PLANNING

Re. Planning Application No. 3/2022/0167 – Smithy Cottage, Birks Brow

PROPOSED PLANS AND
ELEVATIONS

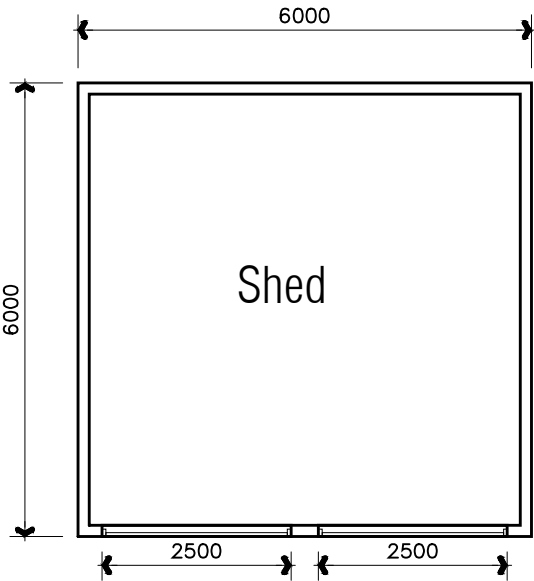
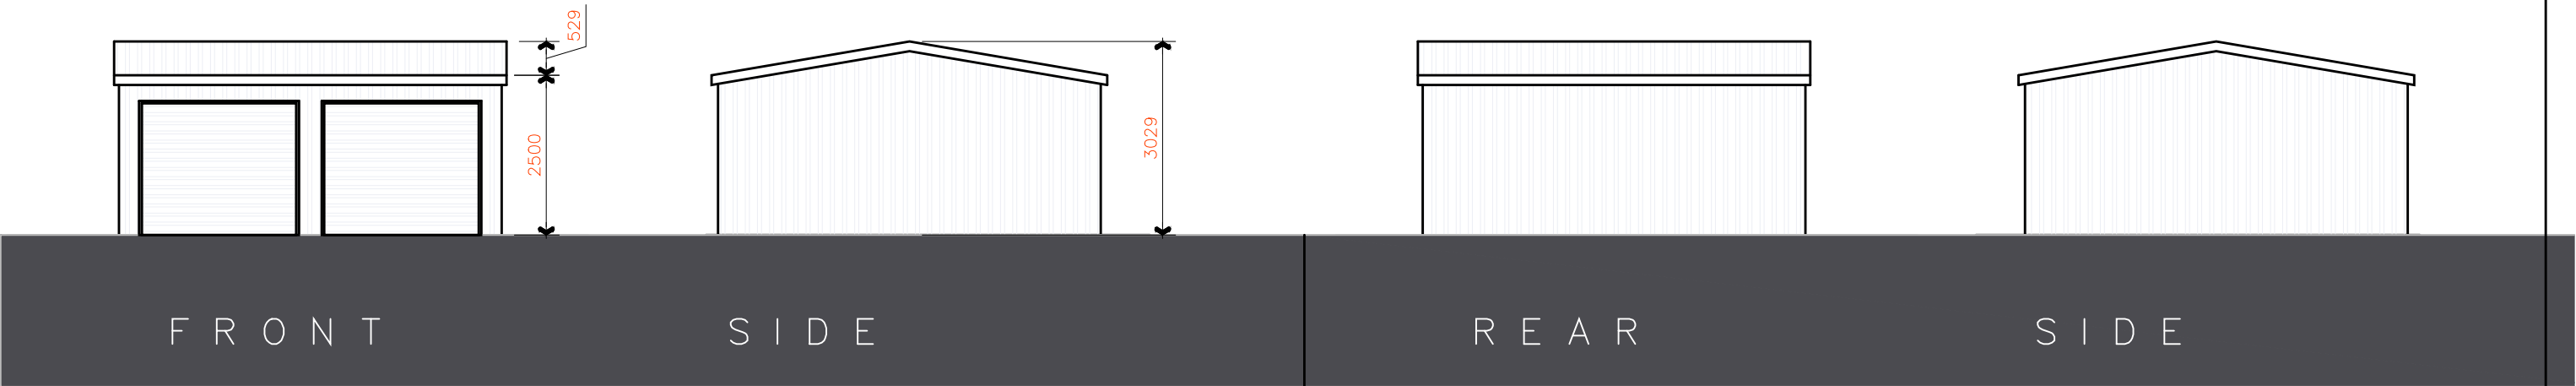
- The application makes reference to a 6m x 6m building but the drawings appear to show a structure which is significantly smaller than this. It is therefore difficult to fully understand the location / impact.
- The orientation of the building is not shown. We assume that the doors will be facing directly west.
- Part of the Council's previous reasoning for rejection was that the proposed location of the holiday accommodation was too far away from Smithy Cottage. We trust that the proposed location of the agricultural building will not pave the way for a future holiday cottage application.
